equinor

Your reference: EN010109
13 January 2023

Planning Inspectorate reference: EN010109
Application by Equinor New Energy Limited (“the Applicant”) for a Development Consent Order for the
Sheringham Shoal and Dudgeon Offshore Wind Farm Extension Projects (“the Application”)
Notification of the Applicant’s intention to submit requests for changes

- C282-MU-Z-XD-00118-01\_F02 – Substation Outline Drainage Plan – Infiltration Method
- C282-MU-Z-XD-00122-01\_F02 – Substation Drainage – Sewer Connection Plan and Long Section

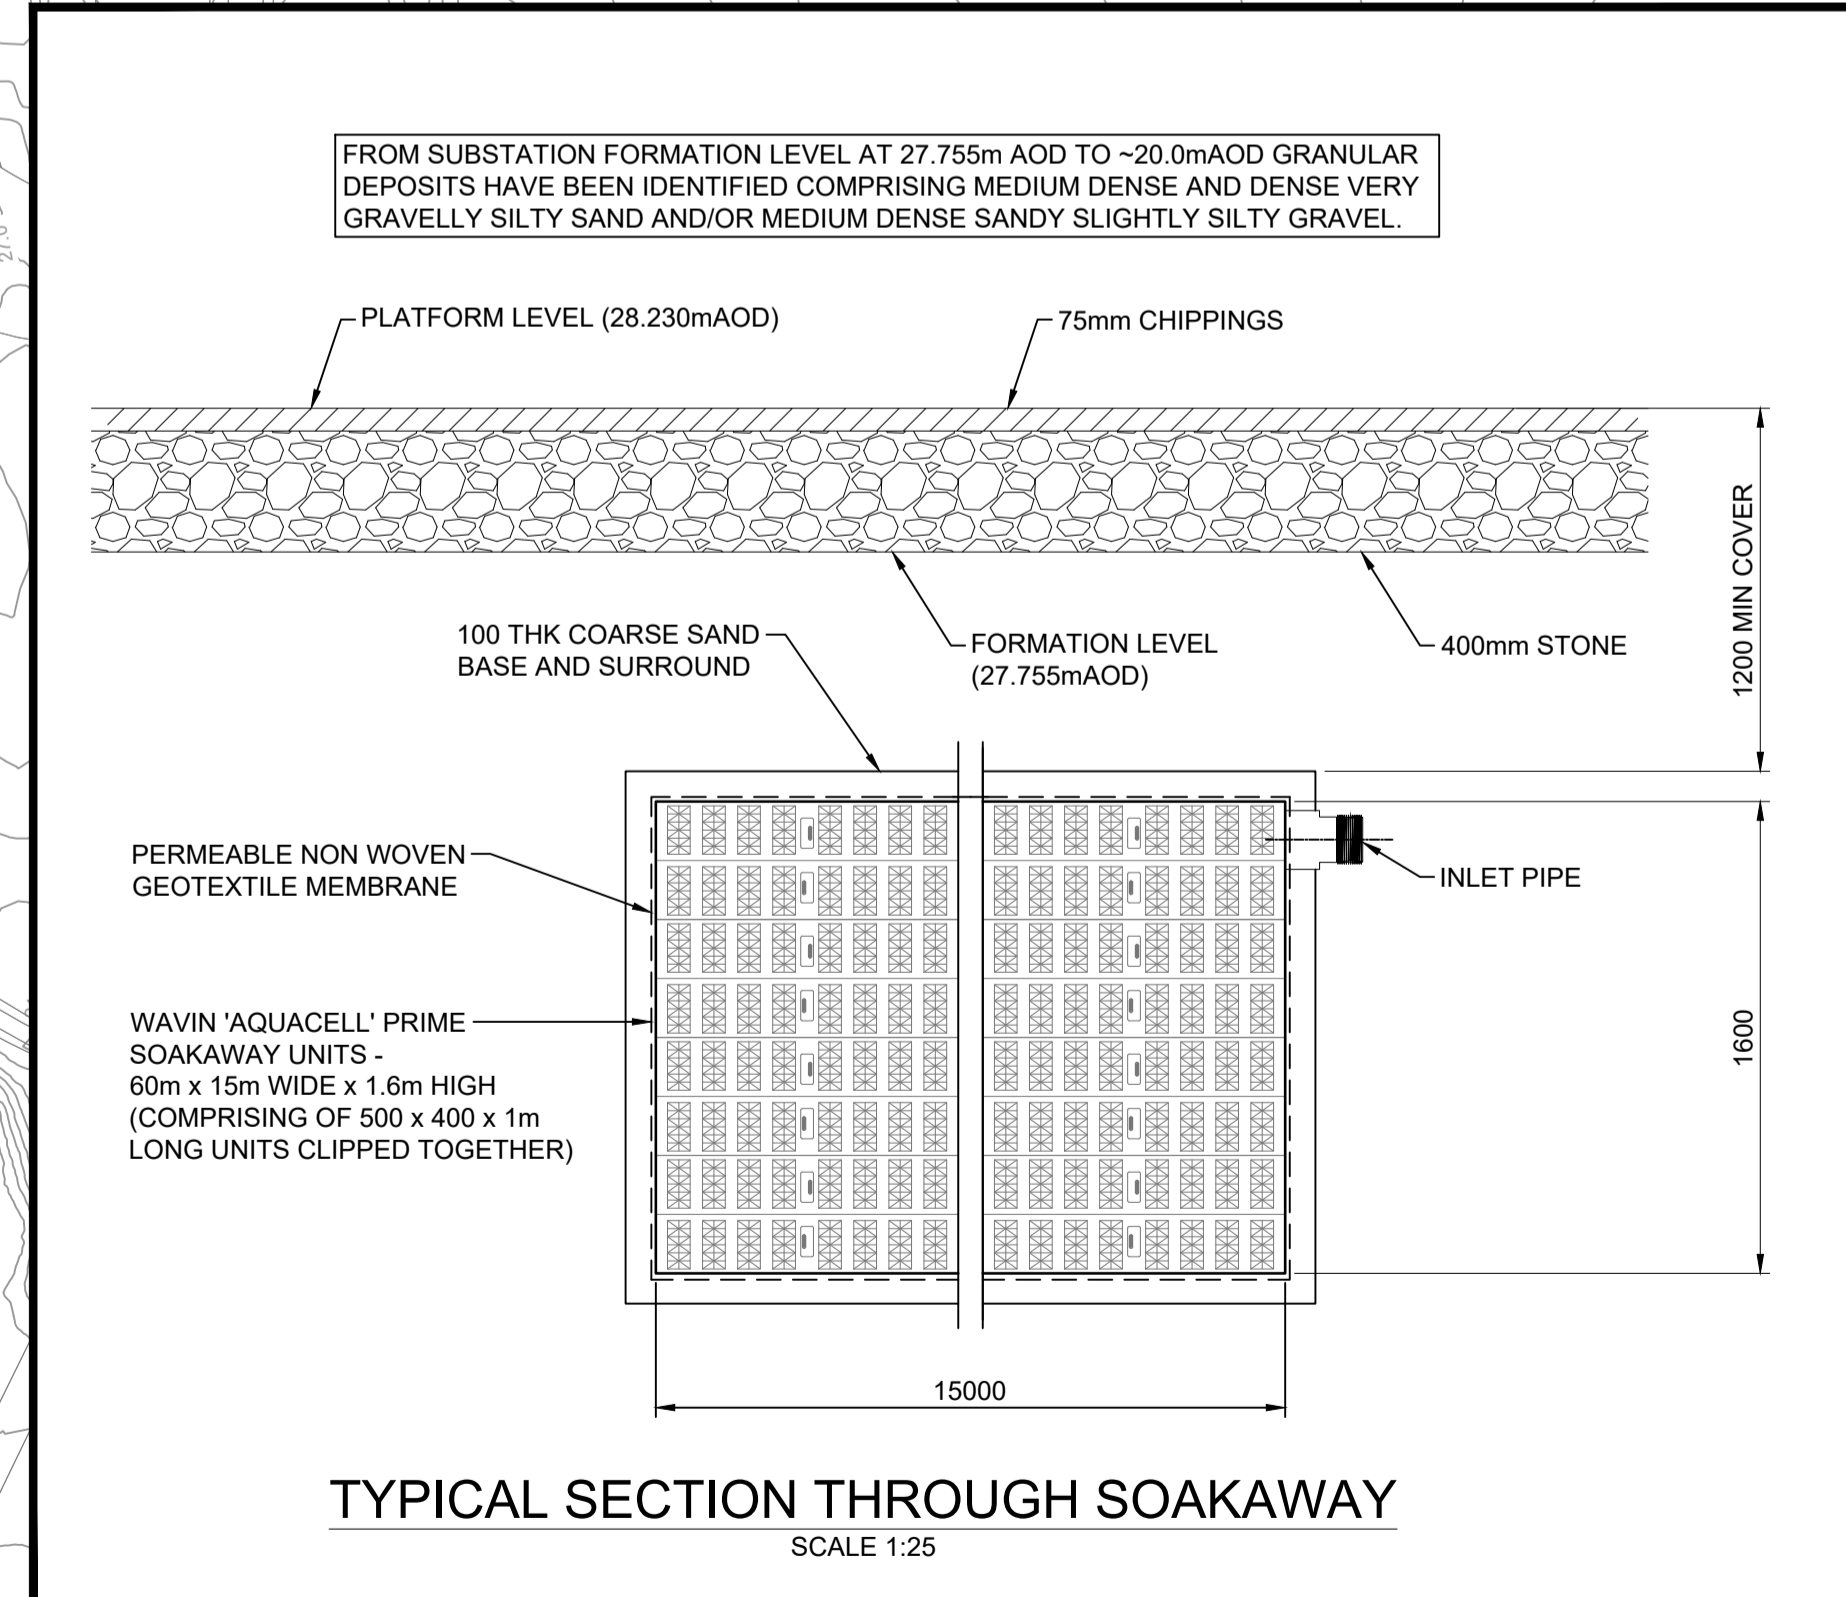
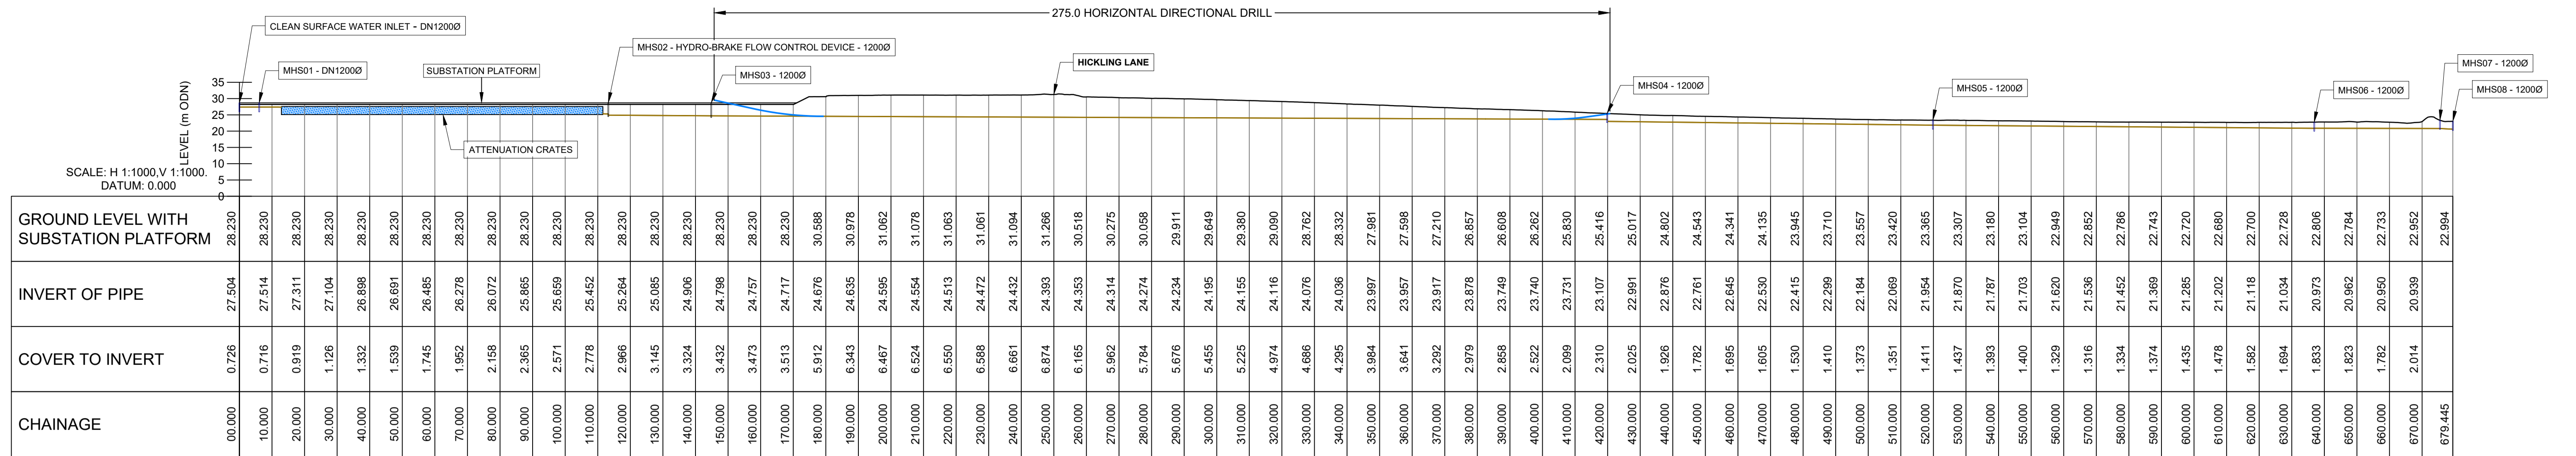
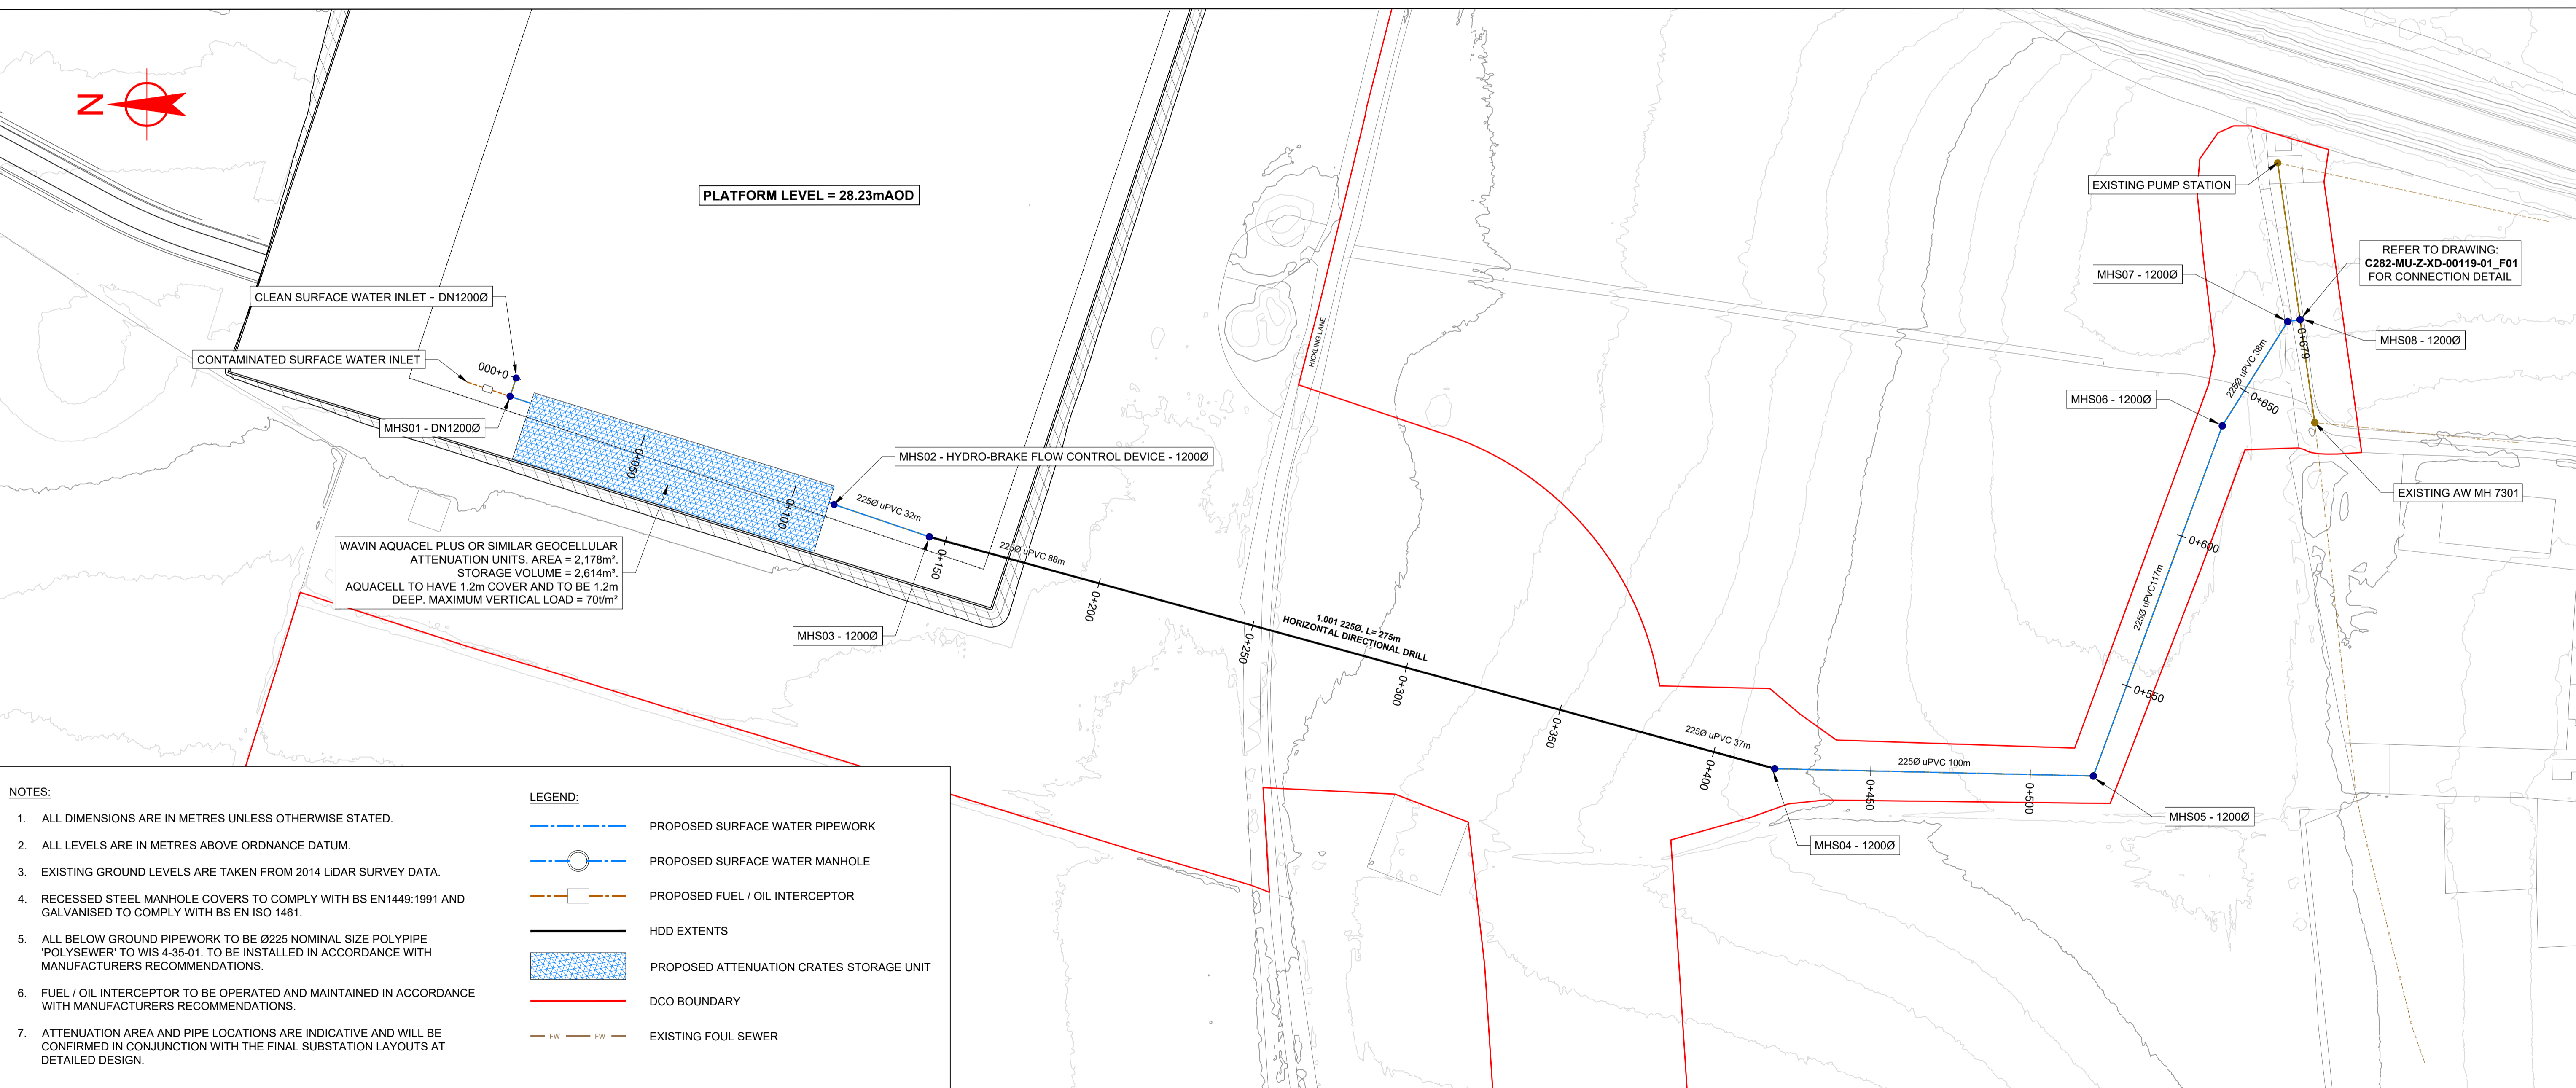
The second change relates to the proposed surface water drainage solution at the onshore substation. Within the DCO application (document reference APP-307) the Applicant presented two options for the discharge of surface water from the onshore substation, comprising either a connection to the Anglian Water foul sewer to the south of the onshore substation site or the use of infiltration adjacent to the onshore substation platform and at the most shallow level possible.

The Applicant has been undertaking further surveys and monitoring in this area which have confirmed that infiltration directly into the shallow granular zone can be adopted. As such, it is proposed that a shallow infiltration solution will be taken forward as the sole surface water drainage approach at the onshore substation.

The Applicant will therefore be requesting a change to the Application to confirm this position and that the connection to the Anglian Water foul sewer option will not be progressed further.
